Application number: 2026/91233	
What is the application for?:	Erection of detached dwelling
Address of the site or building:	50, Orchard Street, Savile Town, Dewsbury, WF12 9LH
Postcode:	WF12 9LH

Type of comment: An objection	
Do you wish your comments to be published on the website anonymously?	No
<p>Dear Planning Officer,</p> <p>RE: Planning Application 2026/62/91233/E – Proposed Detached Dwelling</p> <p>I am writing to formally object to the above planning application.</p> <p>In my view, the proposed development would have an unacceptable impact on neighbouring occupiers and would result in harm to residential amenity through reduced daylight, increased overlooking, an intrusive built form, and the disruption arising from both the construction phase and future occupation of the property.</p> <p>Impact on Daylight and Sunlight</p> <p>The siting, height and overall mass of the proposed dwelling would, in my opinion, diminish the level of natural light currently received by nearby properties. The building would cast additional shadow over neighbouring homes and gardens, reducing daylight to habitable rooms and outdoor areas that are presently well served by natural light. This wou

Site/ Roof Plan As Proposed
Scale 1:100

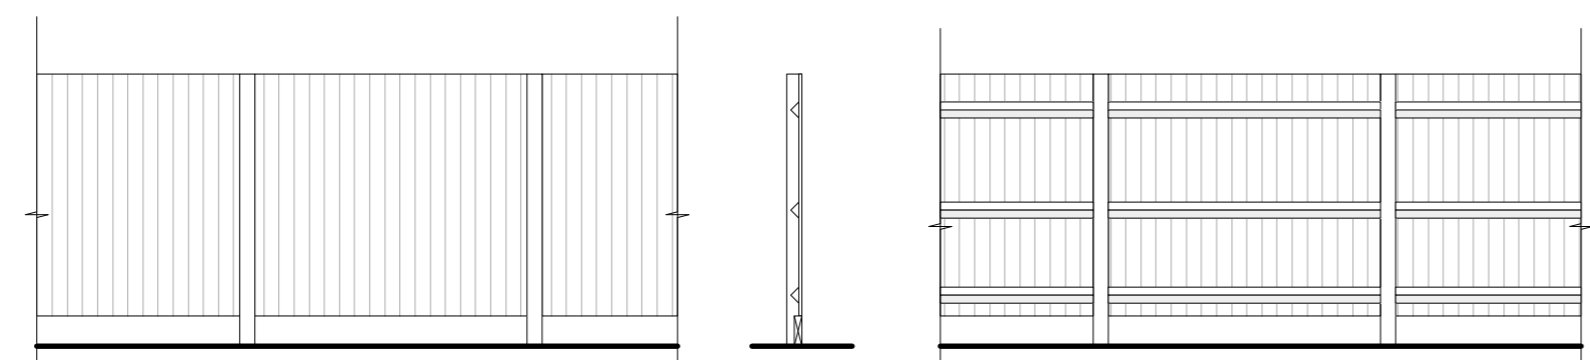
I am also concerned about the proposed access arrangements to the garage. From the information submitted, it appears that access may be reliant upon a road or driveway that is privately owned and does not form part of the applicant's land ownership.

The application documentation does not clearly demonstrate what legal entitlement exists for the applicant to use this land for vehicular access. It is therefore unclear whether the necessary rights, permissions, easements or agreements have been secured from the relevant landowner.

I respectfully request that the Local Planning Authority carefully examine the ownership and legal access position before reaching a decision on the application. The applicant should be required to provide clear evidence demonstrating a lawful right of access over the private land in question.

Without confirmation of such rights, there remains doubt as to whether the development can be implemented in the manner proposed, raising concerns about the feasibility and deliverability of the scheme.
